Project	A13394/VAA - Barnham Eastergate Westergate Parcel SC1
Document Title or Subject	Pell Frischmann Response to West Sussex County Council Highways Comments
Document Reference	A13394/VAA-PEF-XX-XX-TN-TR-000022
Revision Reference	F01 – FINAL
Date	16 December 2022

2 Response to West Sussex County Council Comments

2.1 Rowan Way/A259/A29 and Saltbox/A29/A259 roundabouts

Figure 6.9: Saltbox site AM and PM peak hour development flows

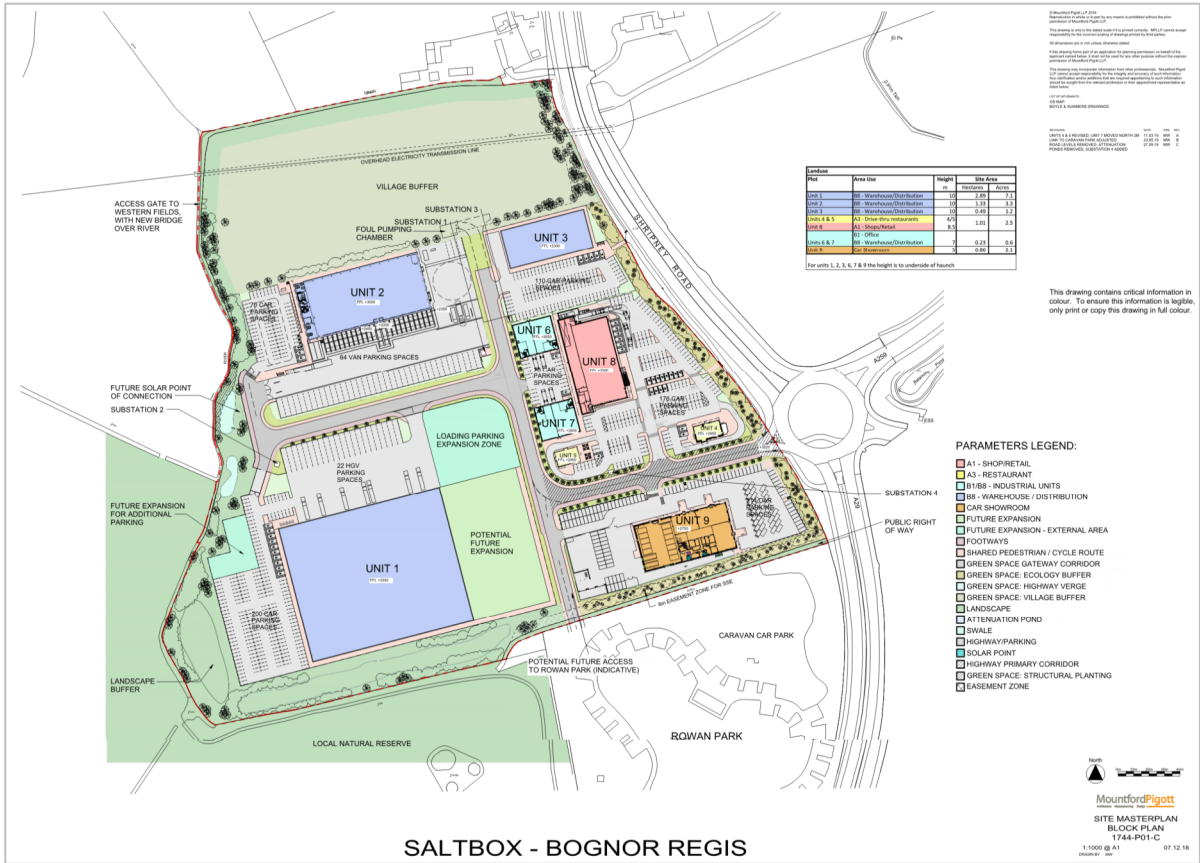
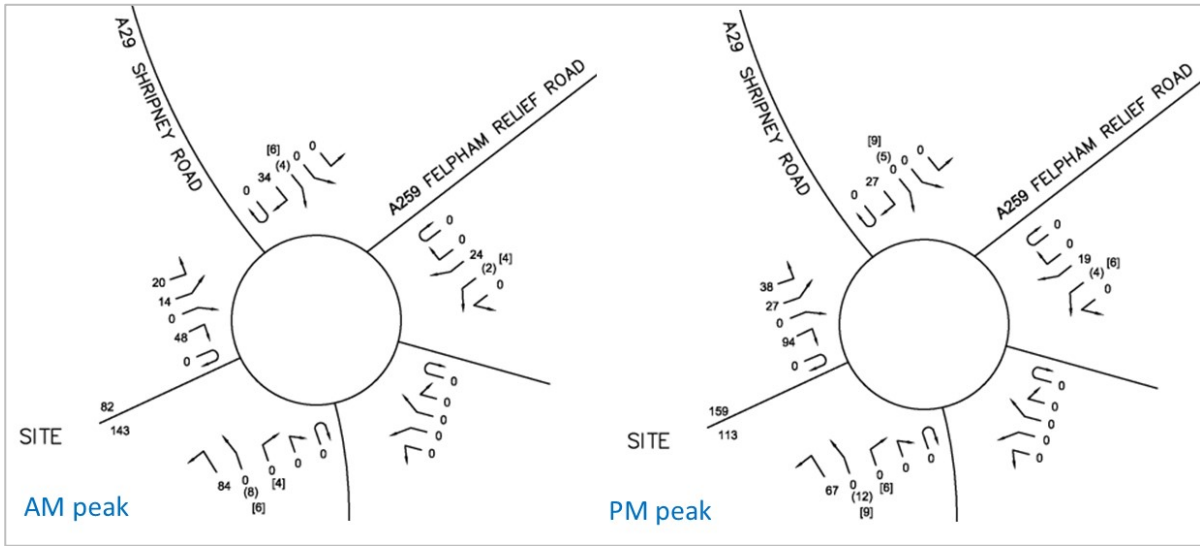
*As you will recall, County requested that a similar/same exercise to the one that National Highways requested be undertaken for both Rowan Way/A259/A29 and Saltbox/A29/A259 roundabouts - i.e. A series of 'stick' turning flow diagrams for those junctions with predicted queue lengths and key turning movements -- specifically showing the **development trips** associated with a 4300 home development and the same for the Local Plan allocation of 3000 homes in order to be able to compare the two.*

In the absence of this information it is still proving very difficult to establish accurate development-related trips and associated impacts at the these roundabouts – particularly Saltbox roundabout using just the supplied figures in your Tables. The key area of concern is Shripney Road North which shows a rise from 0.99 RFC in the 2038 DM scenario, rising to 1.21 RFC in the 2038 DS scenario with resultant large increase in delay and queue length – albeit solely based on a scenario with 4300 homes but with no figures and diagrams from a 3000 home development to compare it with.

- 2.1.8 Refer to pages 75 – 78 in the TA which detail the Saltbox development flows and mitigation, with the queue lengths provided within the traffic modelling results in Tables 6-52 to 6-55.
